Application for a non-material amendment following a grant of planning permission.

Number	54
Suffix	
Property name	
Address line 1	Parkfield Road
Address line 2	
Address line 3	
Town/city	Ickenham
Postcode	UB10 8LW
Description of site location must be completed if postcode is not known:	
Easting (x)	507777
Northing (y)	186746
Description

Two x 2-storey dwellings with habitable roofspace, outbuildings to rear, installation of vehicular crossover to front and associated landscaping works involving demolition of existing bungalow

Reference number:	20899/APP/2018/4135
Date of decision	22/02/2019

B	Mar 2020	Minor changes to internal layout Bay and porch revised
rev no	rev date	info
54 PARKFIELD ROAD ICKENHAM		
GROUND FLOOR LAYOUT A515-01-rev B 1:50(A1)		
Drawn by: AM		Date of issue: Mar 2020

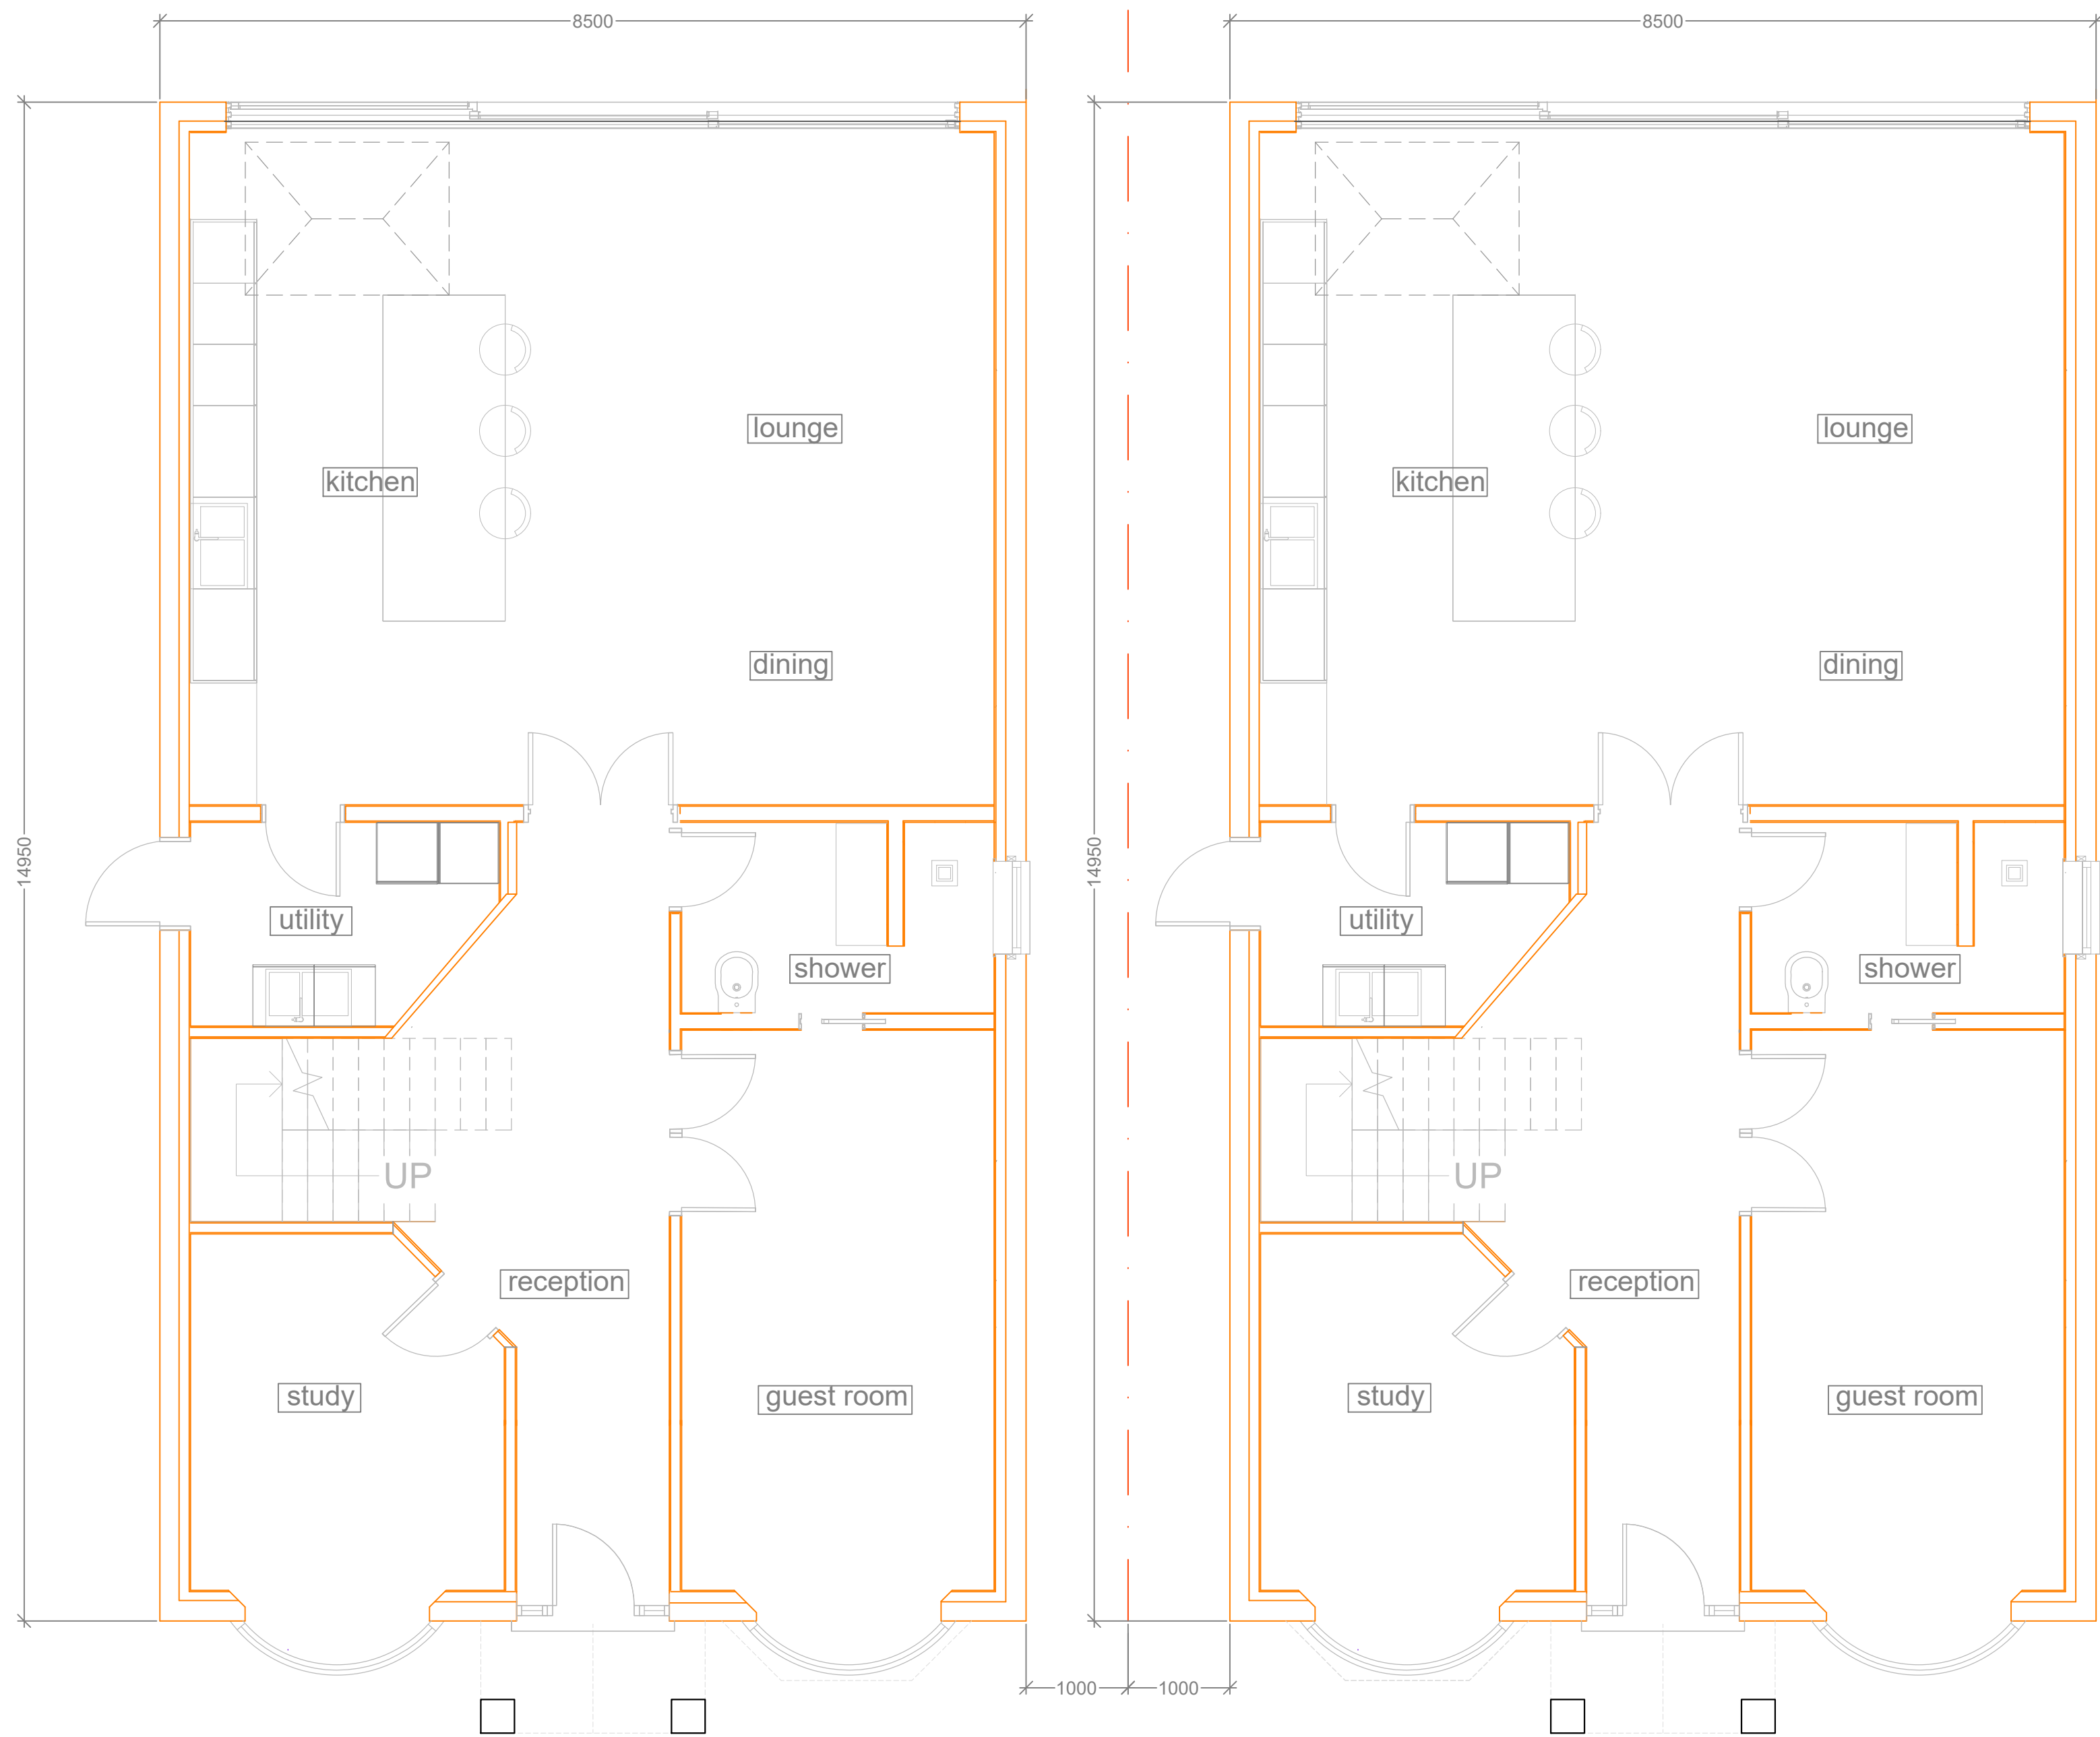
Ground floor - Amended the internal layout
First floor - Amended the internal layout
Loft floor - Amended the internal layout
Roof - Amended the placement and number of roof windows
Front elevations - Amended the front bay so that it is limited to ground floor only
Rear elevation - Amended the window sizes

A515-01-rev B - Ground Floor Layout Side window amendments
A515-02-rev C - First Floor Layout
A515-03-rev C - Attic Floor Layout
A515-04-rev D - Roof Layout
A515-06-rev D - Elevations
